**1st REVIEW – DEVELOPMENT PLAN – APPROVED WITH CORRECTIONS
CIMARRON HILLS FIRE PROTECTION DISTRICT (CH2017-35-DP-1)**

September 17, 2017

The Cimarron Hills Fire Department submitted an electronic development plan to PEAK Consulting Services, Inc. for a fire code compliance review of **TWO** proposed commercial buildings **AT CLARMONT BUSIESS PARK (LOTS 24 & 25)** located at **7258 & 7386 COLE VIEW** within the Cimarron Hills Fire Protection District. This scope of work includes: **Two new 5,000 square foot single story industrial building.**

SITE GRADING & EROSION
CONTROL PLAN

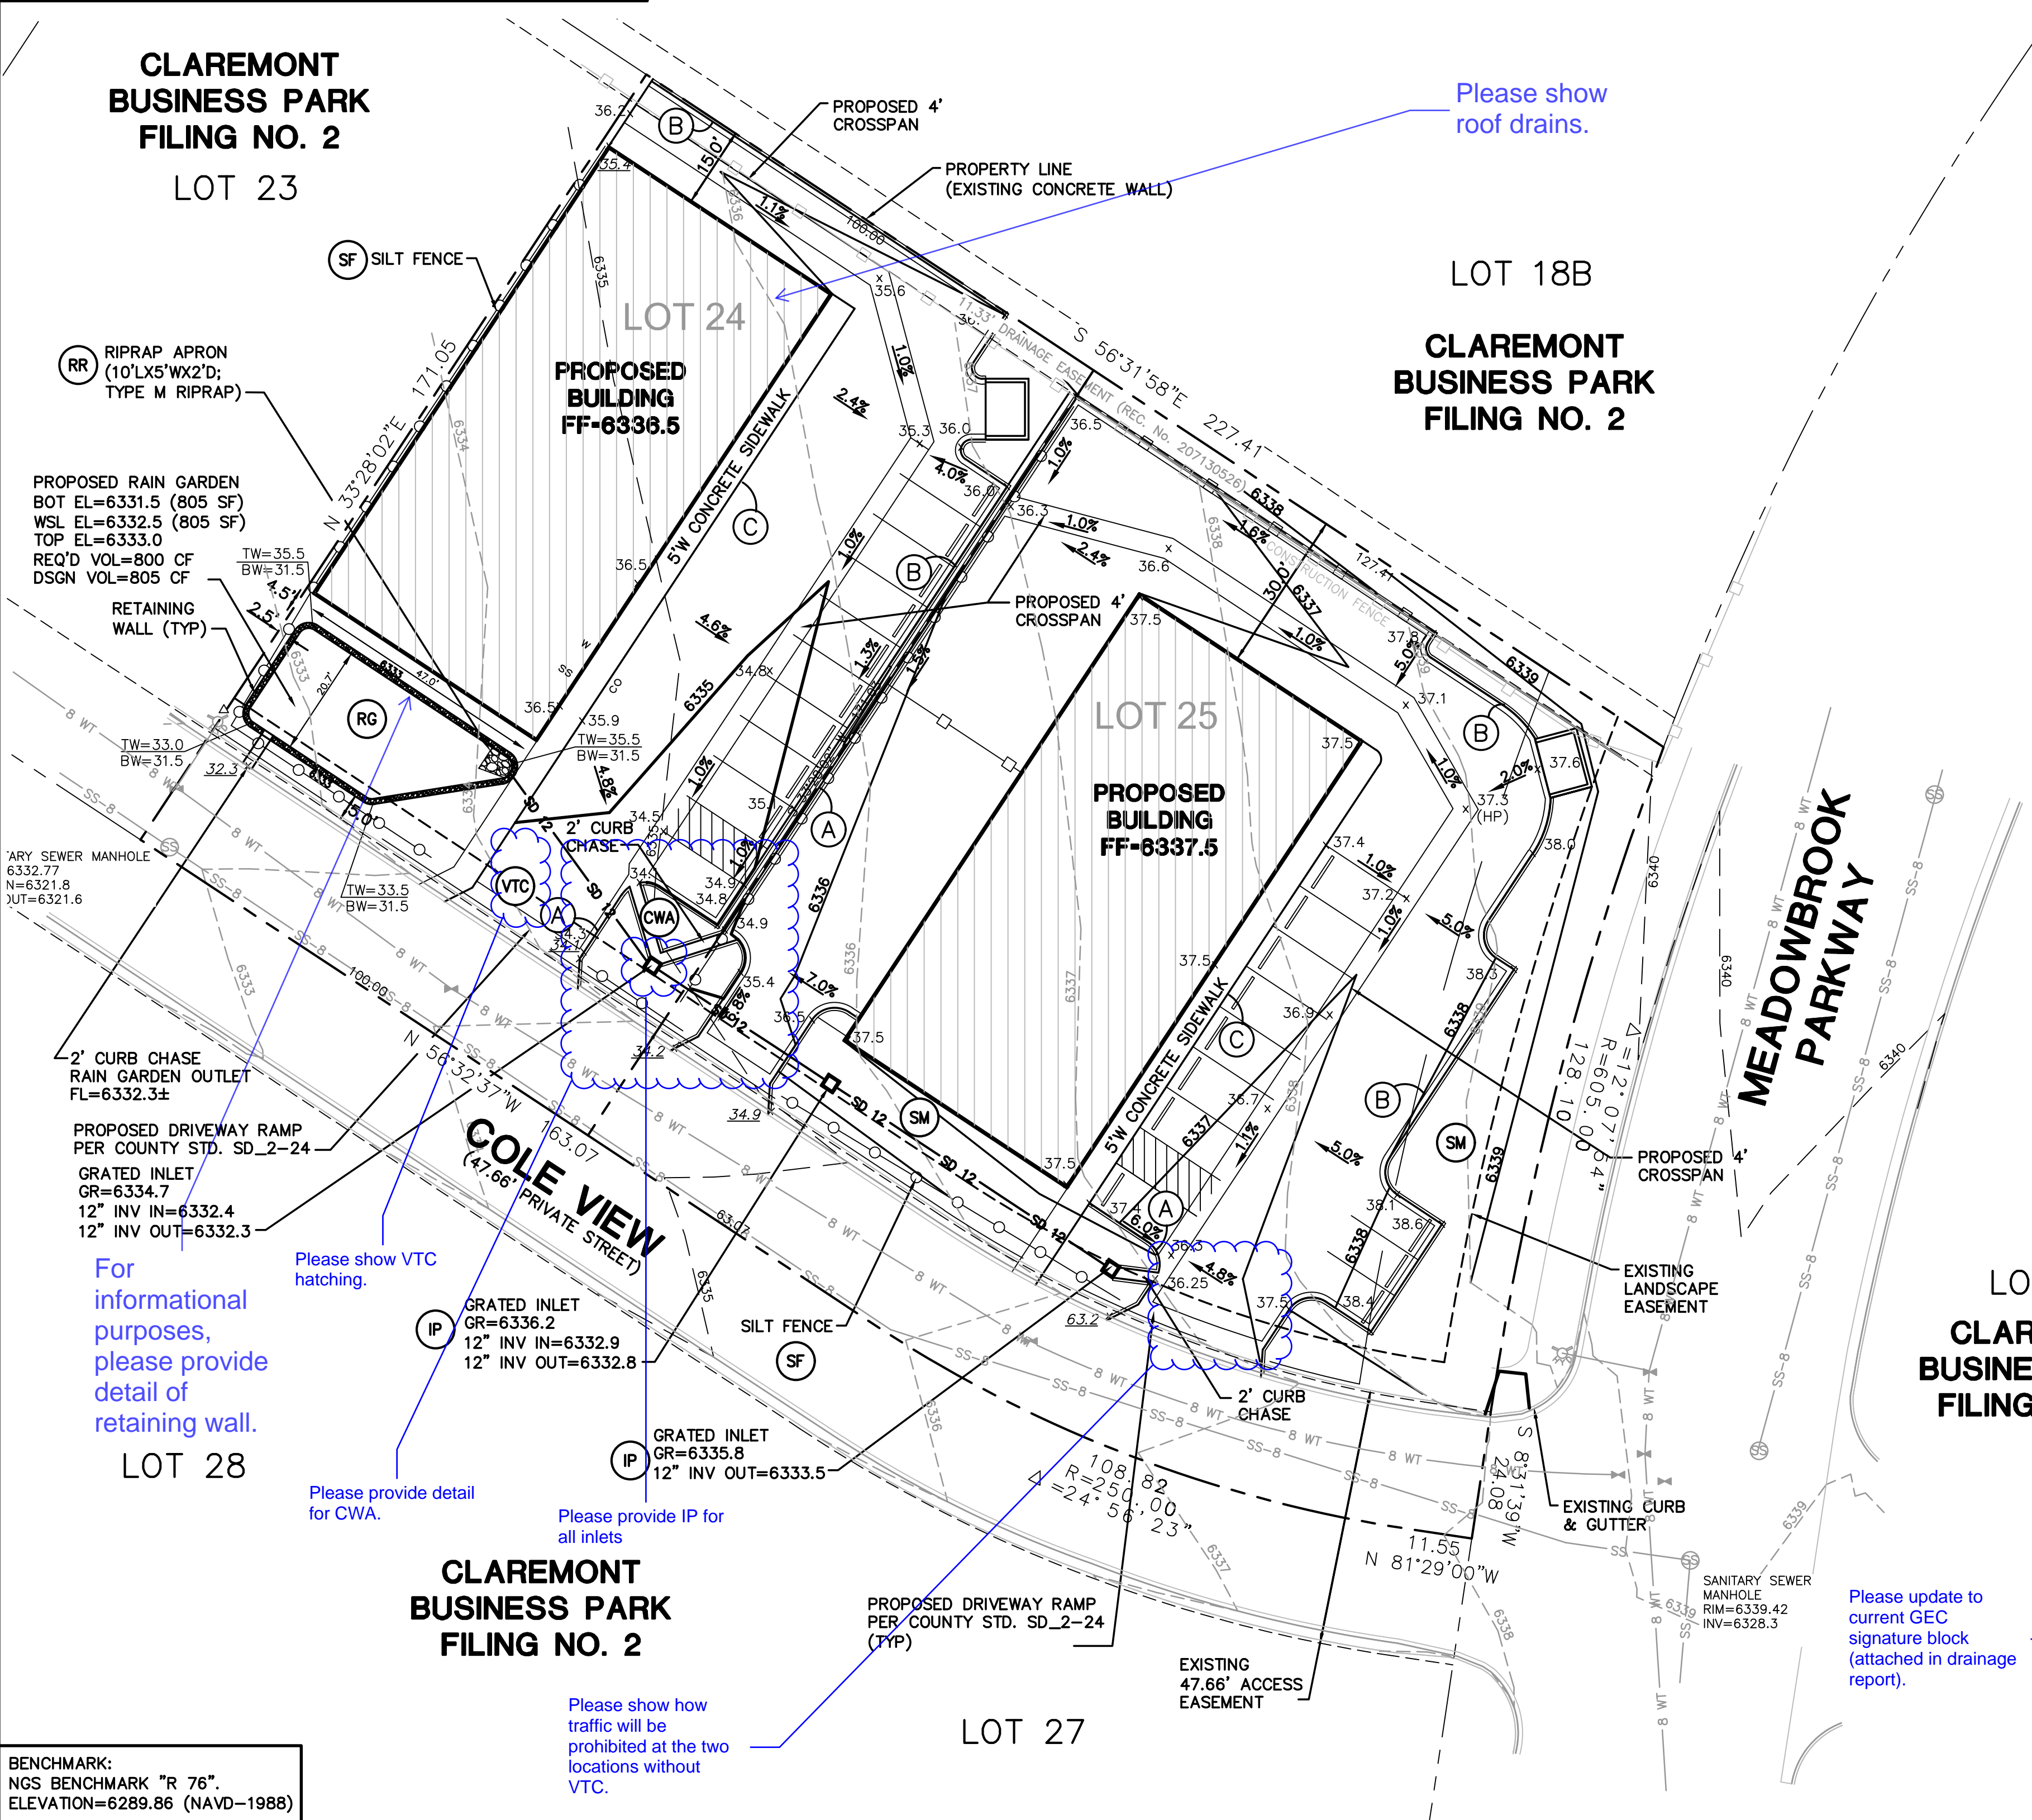
TURNING RADIUS – The East End of this development indicates that there will be RV parking. NOTE: Turning Radius requirements shall be maintained and not impeded upon parked RV's.
